Reference No: **2025/NM/91066/E**

Site Address: 104, Cumberworth Lane, Lower Cumberworth,
Huddersfield, HD8 8PG

Description: Non material amendment to previous permission
2024/93334 for erection of single storey front
extension, installation of new opening and associated
alterations

DECISION – APPROVE NON-MATERIAL AMENDMENT

Working Drawing Elevations

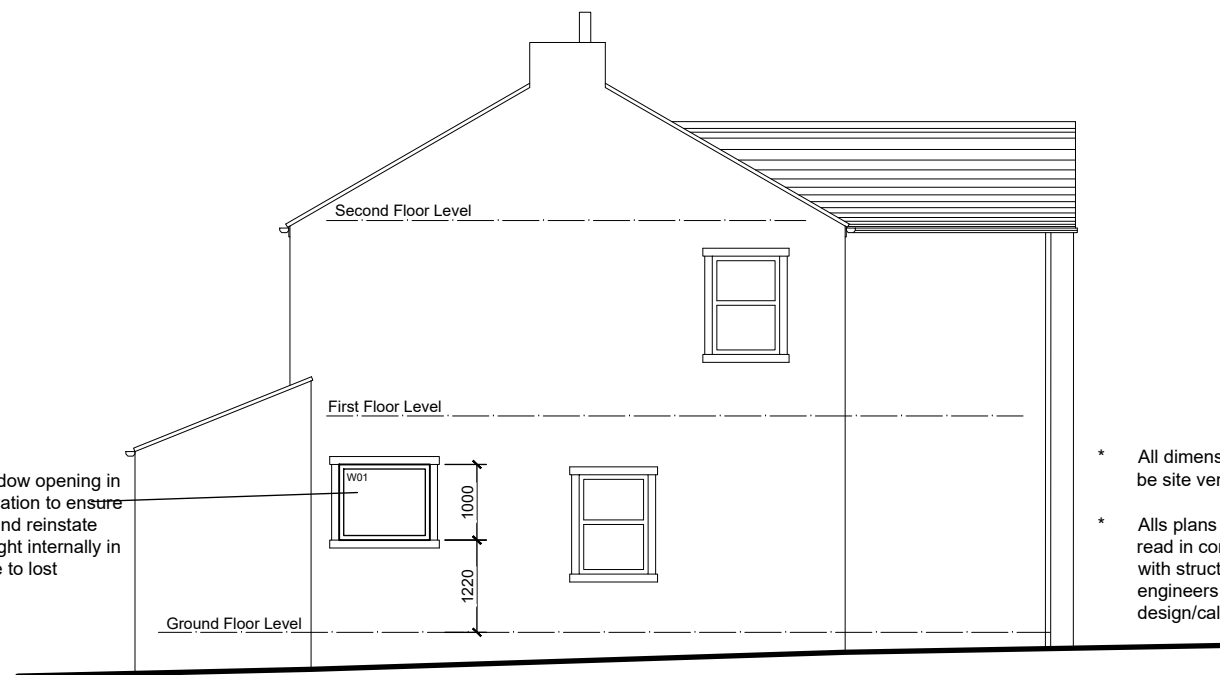
Overview: The applicant requests a non-material amendment to increase the height of the high-level opening along the side elevation from 600mm to 1000mm. this amendment will allow more natural light to enter the main body of the existing dwelling.

would be in keeping with the original dwelling. The fenestration would be located along the north elevation of the dwelling, and given its high level, the window does not provide any additional concerns regarding overlooking.

To conclude, the amendments shown on the submitted drawing '07a - Prop Elevs A3 1-100' to increase the height of the proposed window along the north elevation is considered appropriate to be regarded as a non-material amendment to the previous approval 2024/93334.
